Planning Officer: Ms Louisy-Johnson

Planning Application Ref: AL/81/21/PL

Location: Ryefields Farmhouse, Oak Tree Lane, Woodgate, PO20 3GU

Description of works: Demolition of existing building & erection of 5no houses comprising 1no 4-bed detached, 2no 4-bed link detached & 2no 3-bed detached houses with associated access & parking (resubmission following AL/72/19/PL). This site is in CIL Zone 1 & is Zero Rated

Tree Retention & Protection Plan

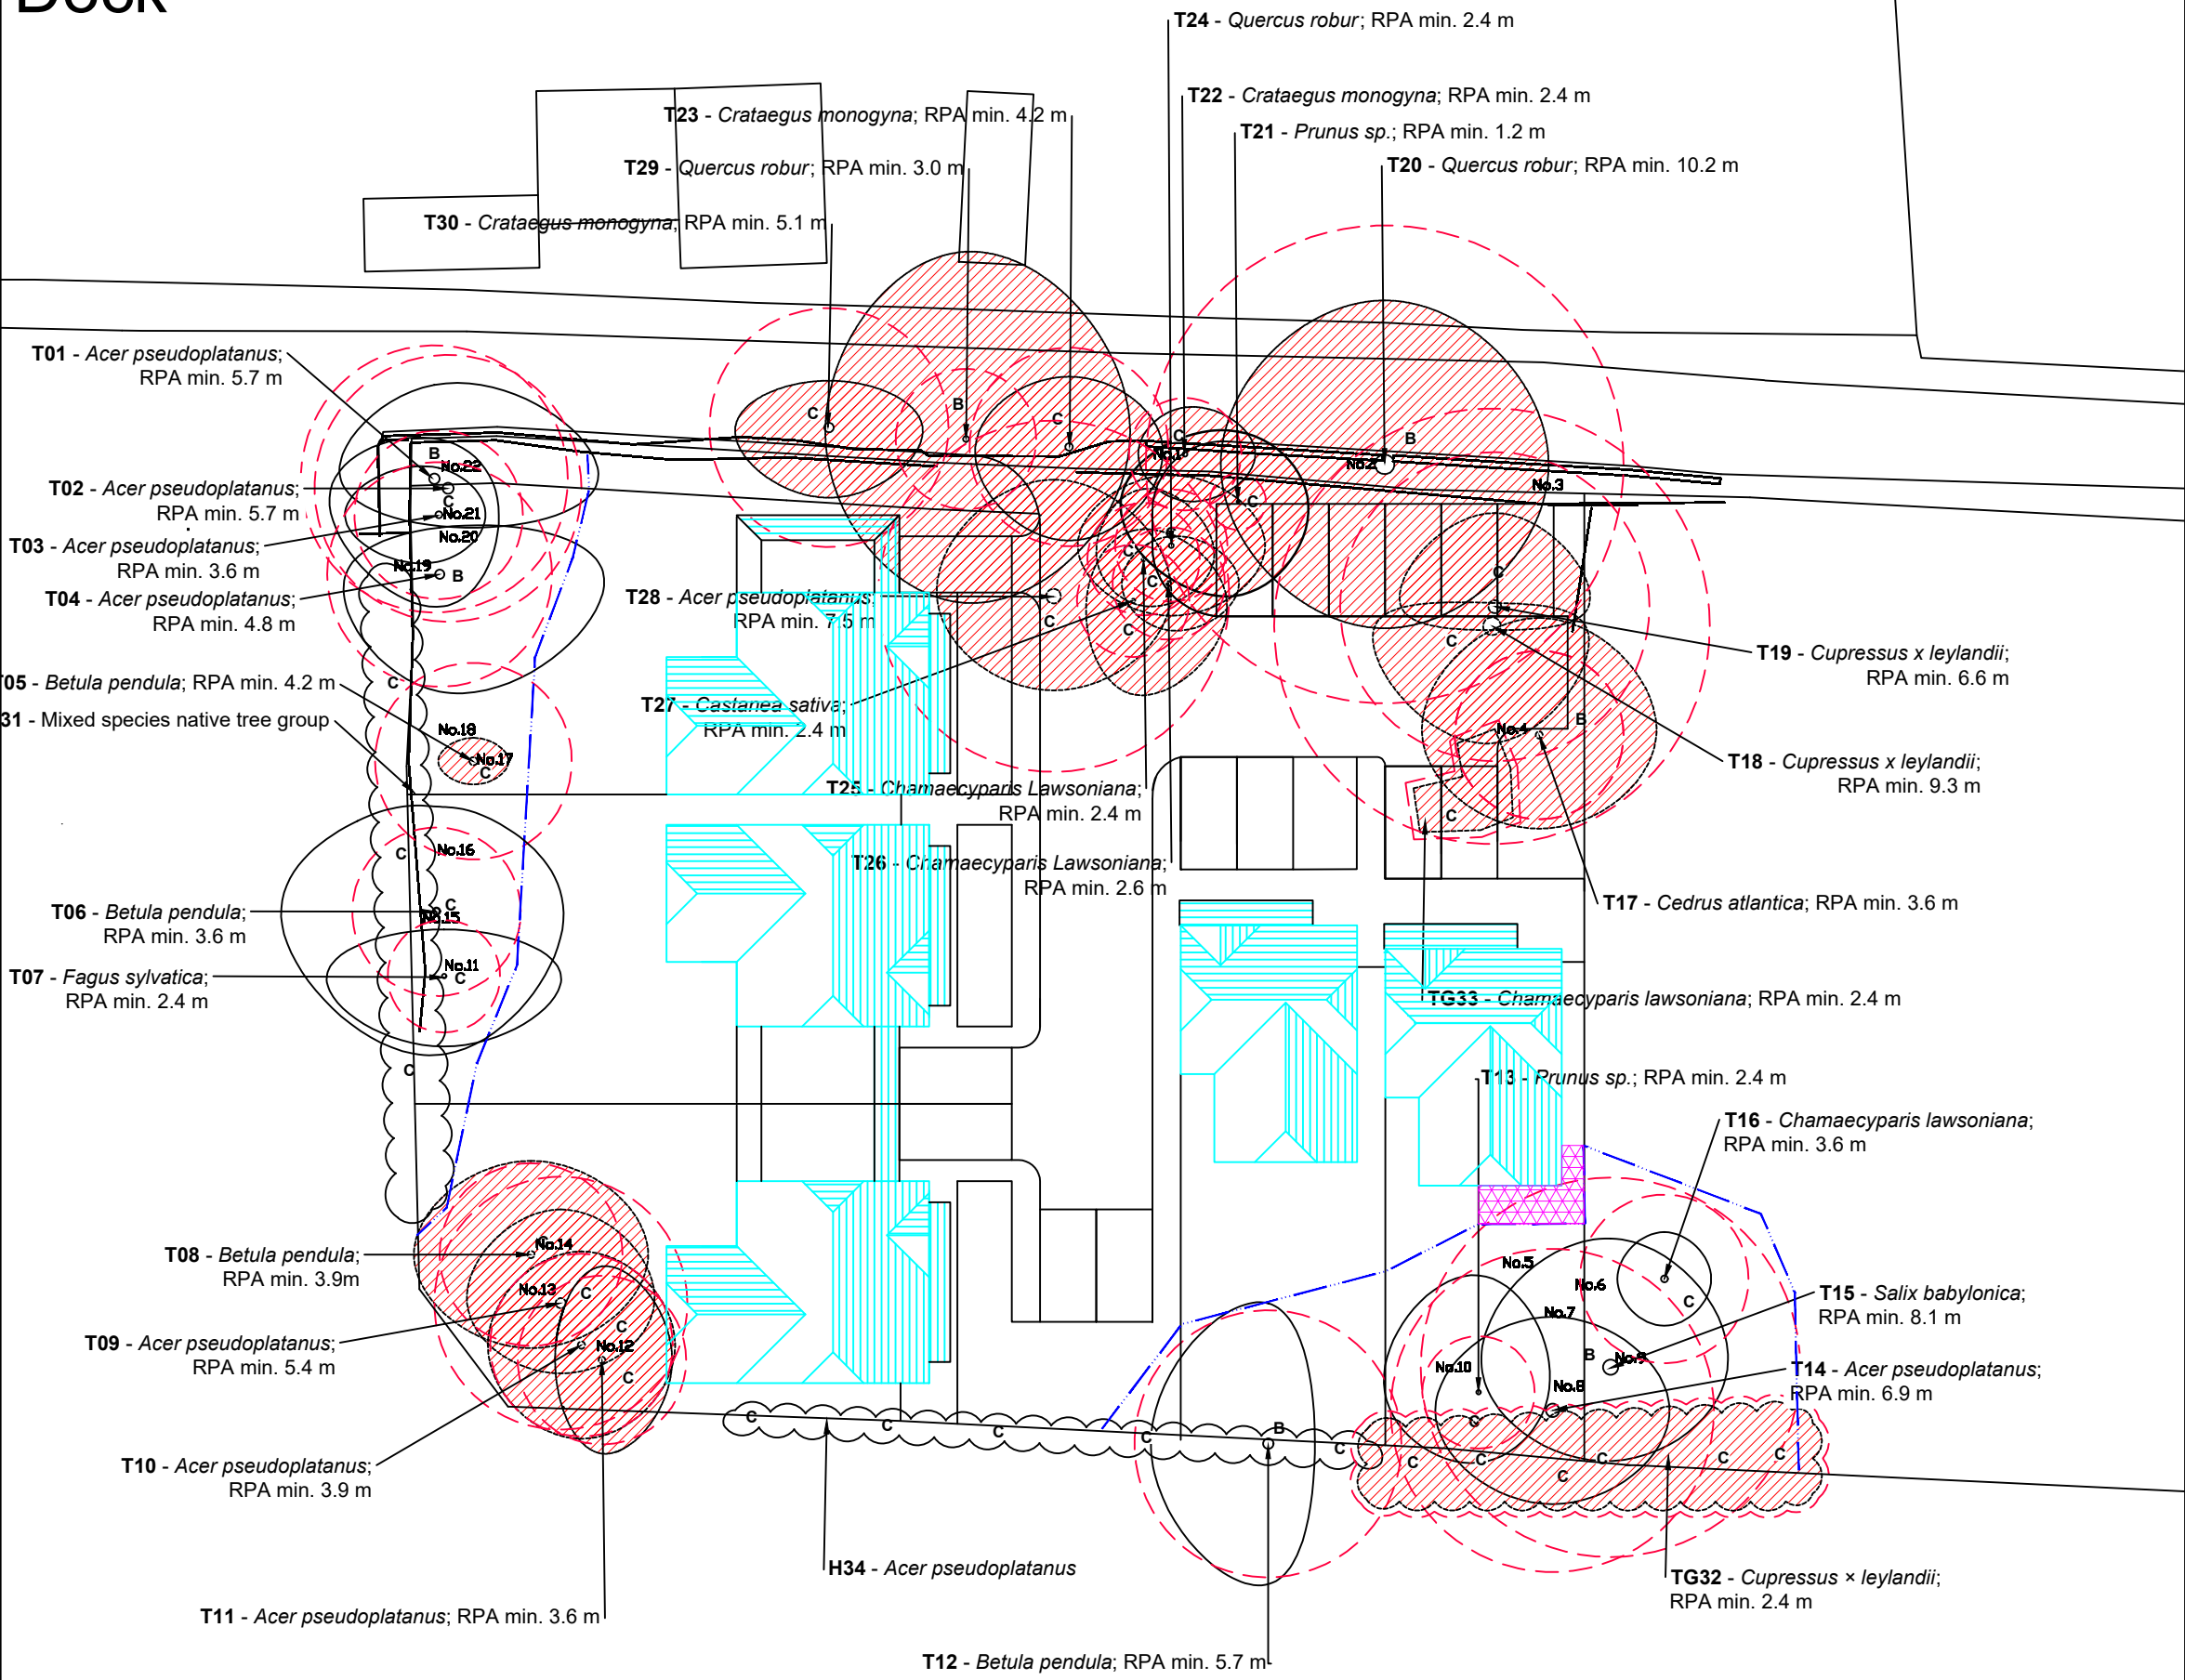
- It is acknowledged that a large number of trees would be removed to facilitate the development, including a mature oak (subject of a Preservation Order). Proposed mitigation measures are not sufficient to compensate for their loss and it is hard to see how they could achieve that with such a configuration of units and parking area. Those trees, particularly roadside, contribute to the character of the area and have public amenity value.

- Several are off-site and appear to be in 3rd party ownership. Notwithstanding the above, if approval is given for this application in current form without adequate mitigation for construction within Root Protection Areas and 3rd parties do not consent to the removal of their trees – significant damage to those trees is highly likely to occur.

- I find this latest application to be ill-conceived in arboricultural terms and layout inferior to that previously submitted. I cannot support the removal of principal off-site tree (oak – T20) to facilitate any scheme for this plot. A development that respects and accommodates the higher quality trees and those of long-established landscape value is achievable, yet there is no aspiration to do so here.
- Trees of lesser quality and landscape value could be sacrificed to allow a sympathetic development although a reduction of units may need to be accepted. That is reasonable and of itself would not incur undue detriment to the visual amenity of surrounding area, which together with adequate mitigation (native tree and hedgerow planting) I could support.
